COUNTY COUNCIL'S RESPONSE TO CONSULTATION ON THE FOLLOWING DEVELOPMENT PROPOSAL

Application No: 20/00293/OUT-4

Proposal: Outline application (Phase 1B) including access (all other matters reserved) for approximately 4,413 sqm B1 office space (47,502 sqft) GIA, approximately 273 residential units (Use Class C3) including ancillary gym, approximately 177 sqm GIA of café space (Use Class A3), with an ancillary, mixed use co-working hub (794 sqm/ 8,550 sqft GIA), multi-storey car park, multi-use games area (MUGA), amenity space, associated infrastructure, parking and marketing boards

Location: Bicester Gateway Business Park, Wendlebury Road, Chesterton

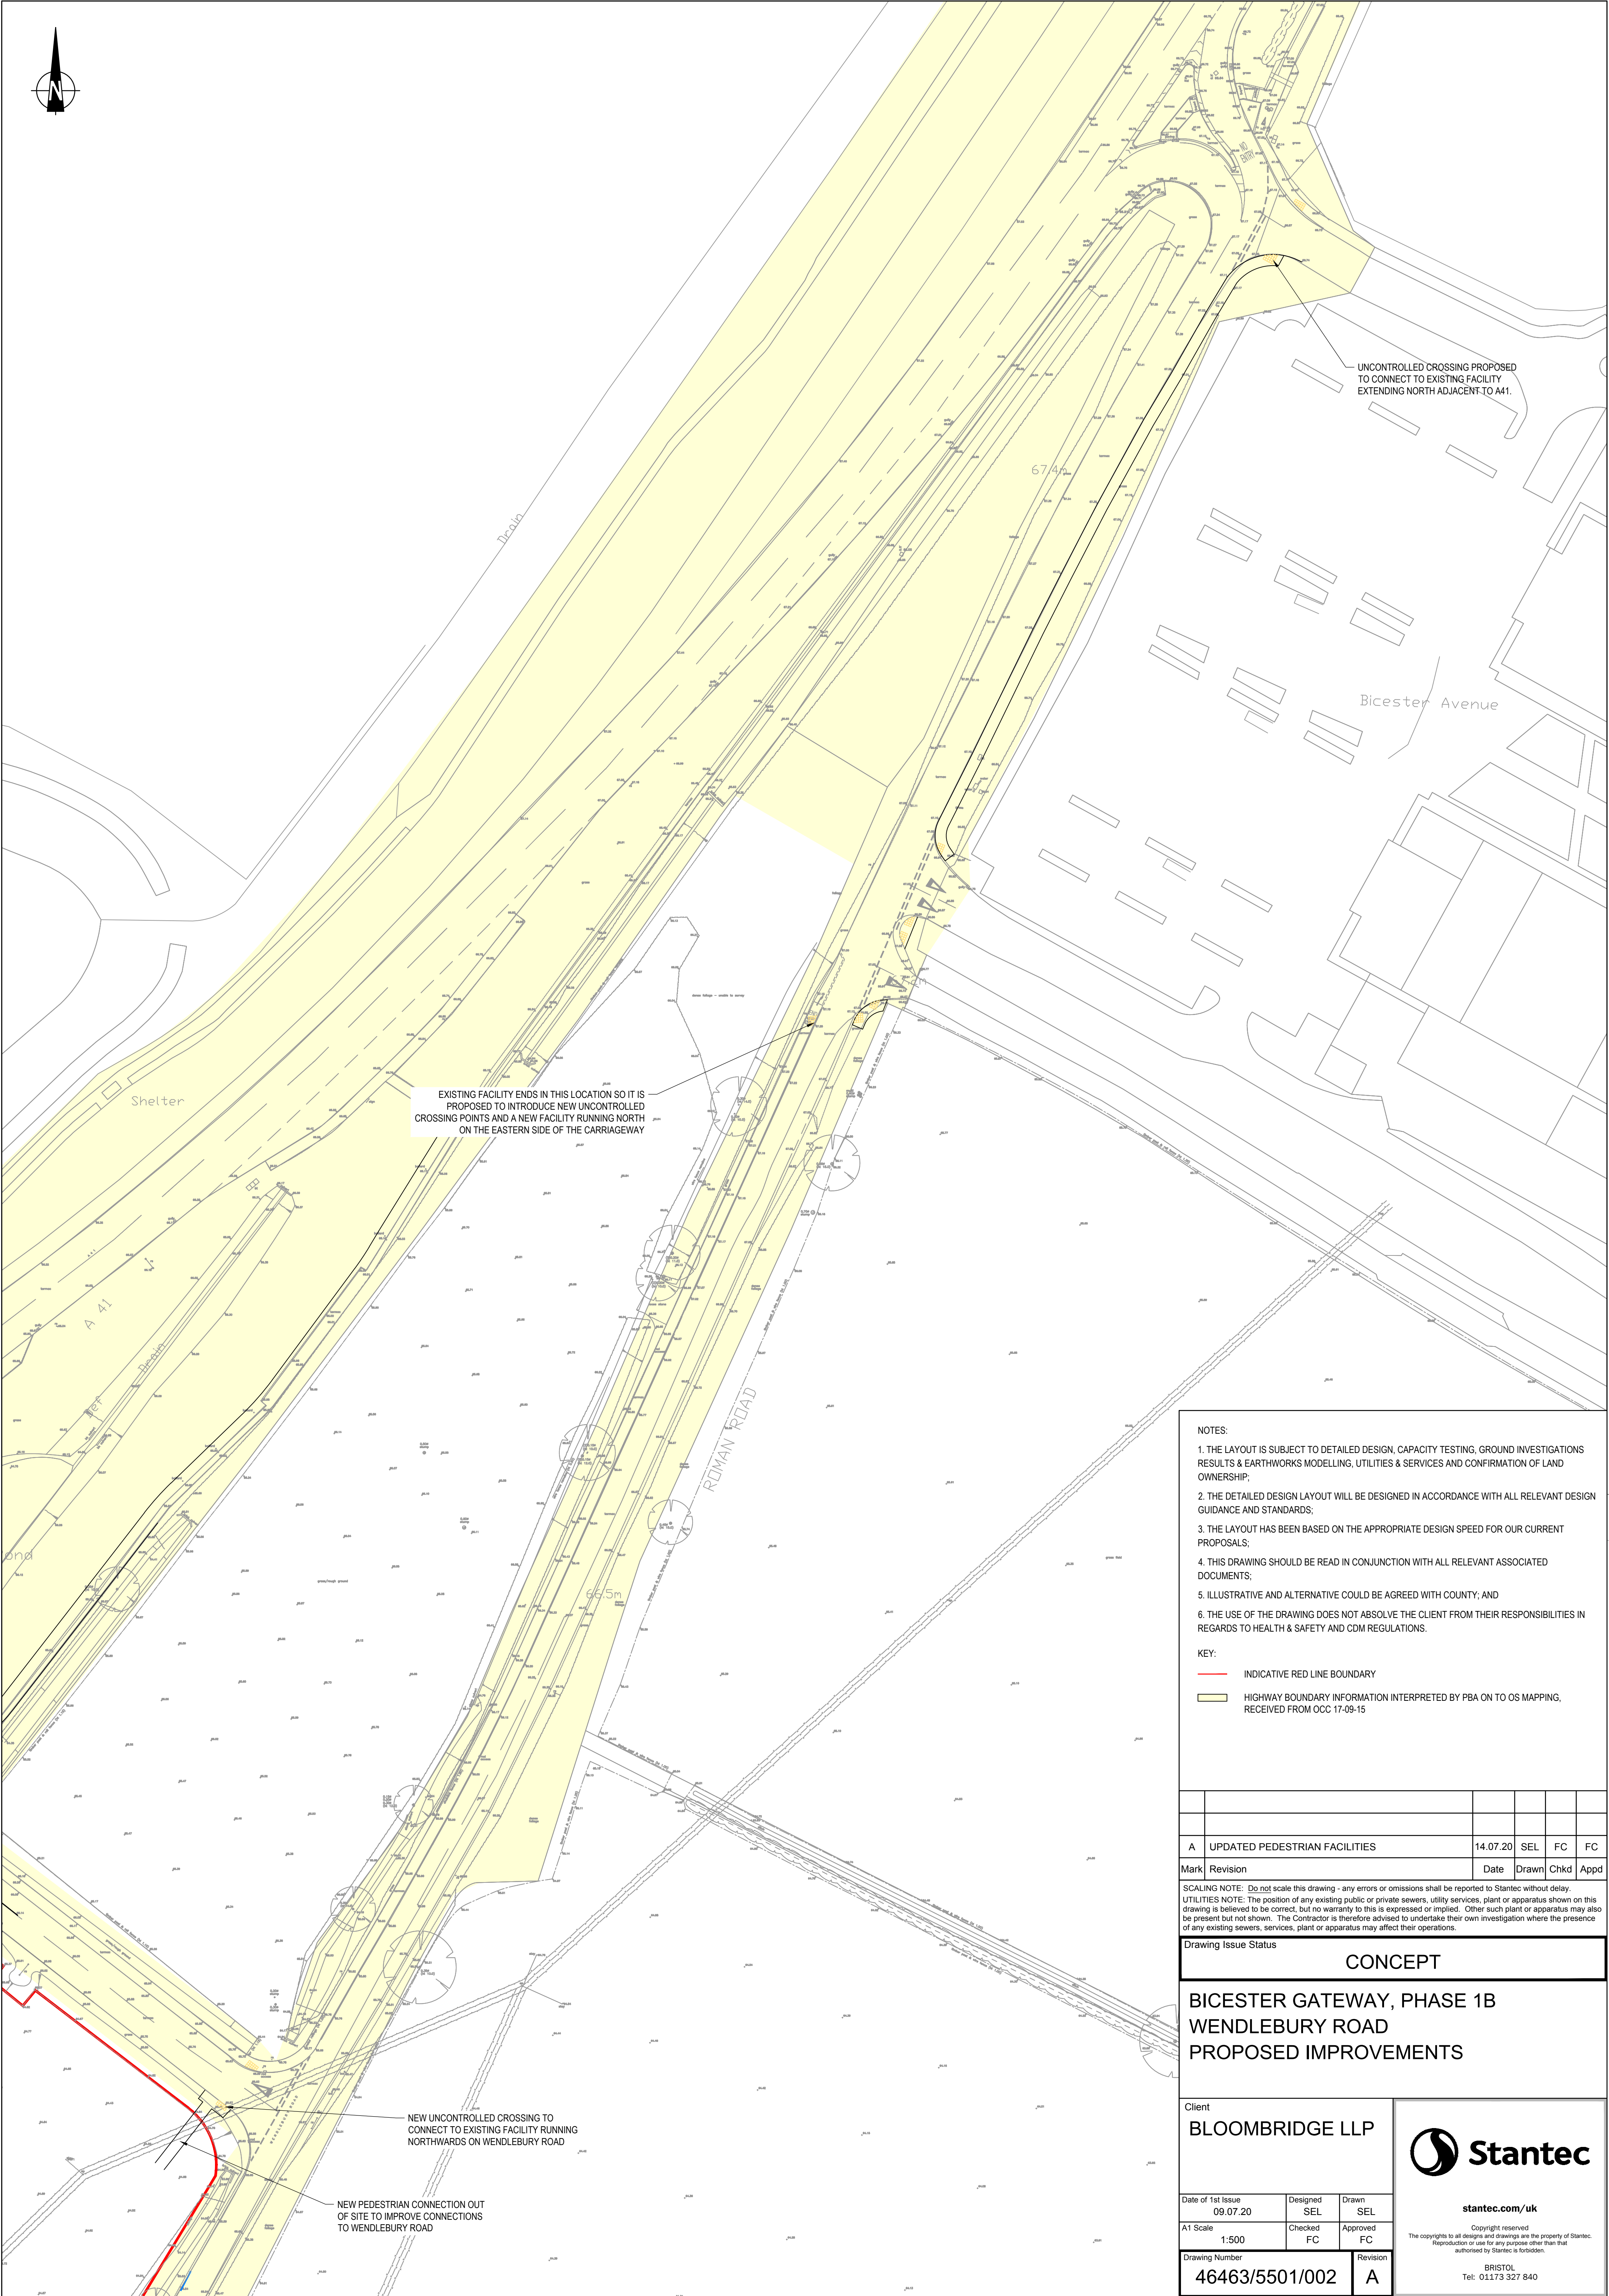
Drawing no. 46463/5501/001 Rev C

- This layout shifts the crossing point about 10metres further east across Charles Shouler Way and away from the Vendee Drive roundabout – which addresses the issues flagged with the previous Rev B, i.e. proximity to the roundabout and departure from the desire route.
- The pedestrian island provides refuge to enable a two-phased crossing approach. The island has sufficient width to accommodate a pair of cyclists and a limited number of pedestrians at any one time.
- The arrangement avails adequate visibility for approaching vehicles from both sides of the crossing. Conversely, pedestrians on both the nearside and the far side from which their crossing movements may begin have been provided with additional waiting width needed in advance of crossing.

The layout presented by Rev C plan is considered acceptable.

Besides the crossing point, the other outstanding feature presented by the new arrangement illustrated by Drawing no. 46463/5501/001 Rev C removes an entry approach lane of Charles Shouler Way arm in order to accommodate a pedestrian island.
